## 1 INTRODUCTION AND BACKGROUND TO REPORT

This document provides a response to the Third Party Submissions made by various parties on the response Jennings O'Donovan submitted (the Submissions Response Document) in response to the submissions received on the Strategic Infrastructure Development Application Reference ABP-317560-23 made to An Bord Pleanála by Mercury Renewables (Carrowleagh) Limited, for the construction of a wind farm and hydrogen plant and related works. This document addresses the submissions received individually. The responses on behalf of the Applicant are in blue while submission text is in black.

Re: ABP -317560-2324

Proposed windfarm development including 13 no. wind turbines in Bunnyconnellan, Co. Mayo and hydrogen plant in Castleconnor, Co. Sligo.

Figure 1.3 Hydrogen Plant Site House Locations

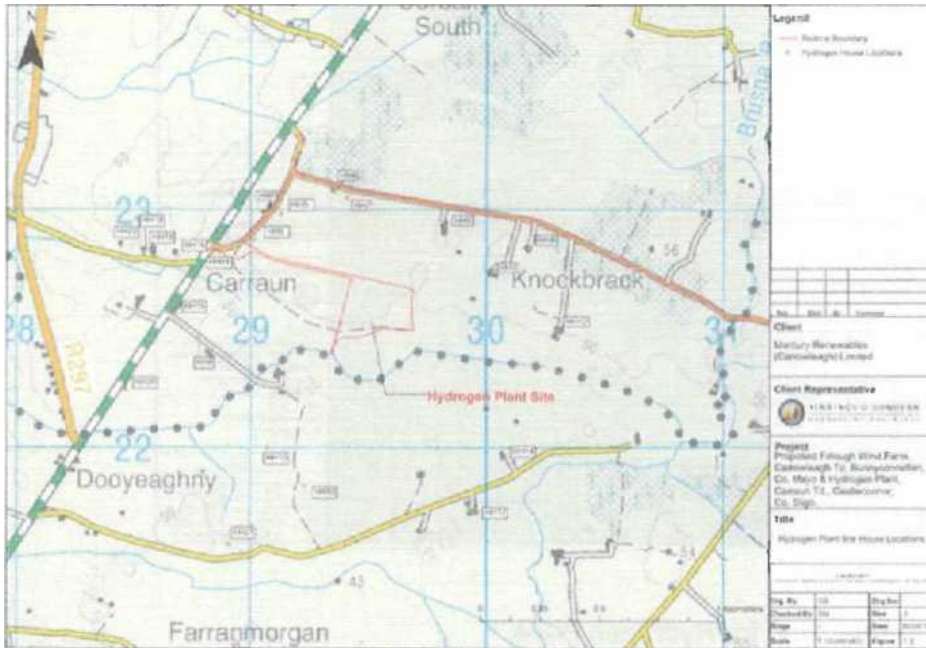
Figure 1.3 in the EIAR shows Hydrogen plant site house locations. This is referred to in the Noise and Vibration chapter 11 of the EIAR. However, due to inaccuracies re houses Hh10 and HH13 detailed in this chapter, (which don't exist) I fear that other information in this chapter may also be incorrect.

*House maps were prepared using Ordinance Survey maps, arial photography, a house survey based on Eircodes and periodic and repeated planning searches for new developments with planning permission. Section 2 of this report substitutes 2 Figures of the EIAR due to a minor error in the location of HH10 and HH13. The amended figure identifies these houses as the unused houses mentioned above.*

- The correct location of HH10 is 610m from the Hydrogen Plant (compared to 600m in Figure 1.3).*
- The correct location of HH13 is 830m from the Hydrogen Plant (compared to 680m in Figure 1.3).*

*These are both derelict and disused properties without Eircodes.*

*The distance and location corrections do not significantly change the impacts addressed in the noise assessment in Chapter 11 or any other technical assessments.*

*These properties are outside any noise contours. The difference between the location assessed and the correct location is minimal, the correct locations are both further from the location assessed and therefore the noise impacts would be lower.*

Figure 11.9 Noise Contour Map for Hydrogen Plant

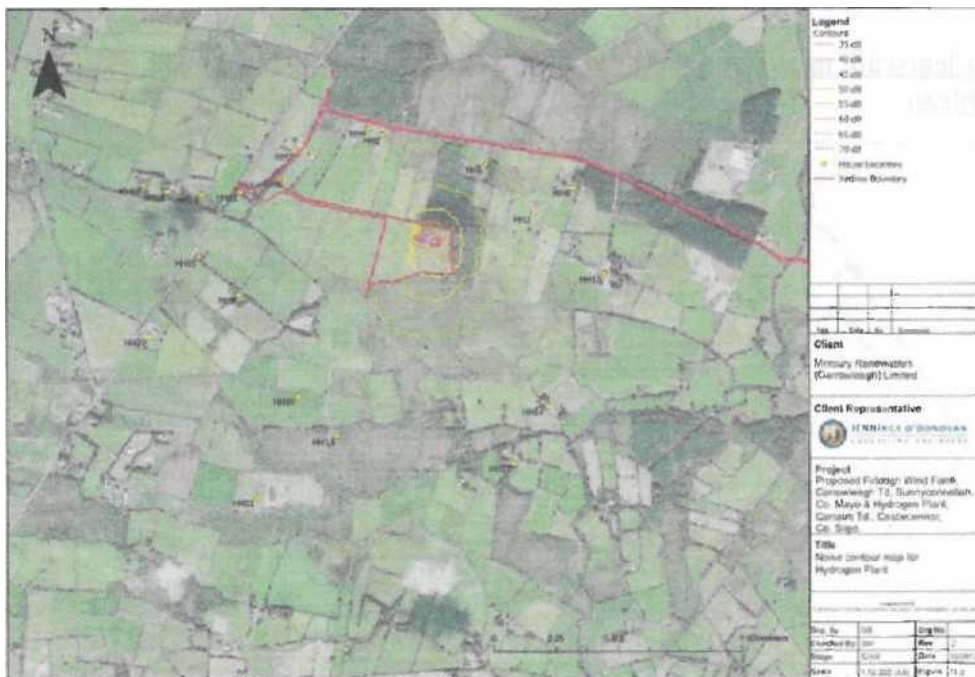
In the intervening period since the application was submitted, it has become apparent that a minor error in the location of two derelict and disused house locations was made in Figure 1.3; Hydrogen Plant Site House Locations and in Figure 11.9; Noise Contour Map for Hydrogen Plant.

House numbers HH10 and HH13 have been mapped in error approximately 500m west of their correct location. This does not affect the technical assessments. These are both derelict houses and the corrected locations are further from the Hydrogen Plant than the location assessed in Chapter 11 Noise. The noise impacts would therefore be expected to be slightly lower than those identified. The derelict house locations are both well outside the noise contours.

- HH10 was mapped as 600m to the southwest of the Hydrogen Plant, the correct location is 610m to the southeast of the Hydrogen Plant.
- HH13 was mapped 680m to the southwest of the Hydrogen Plant, the correct location is 830m to the southeast of the Hydrogen Plant.

For the avoidance of doubt Figure 1.3 and Figure 11.9 of the EIAR has been updated to include the corrected location of these two derelict houses.
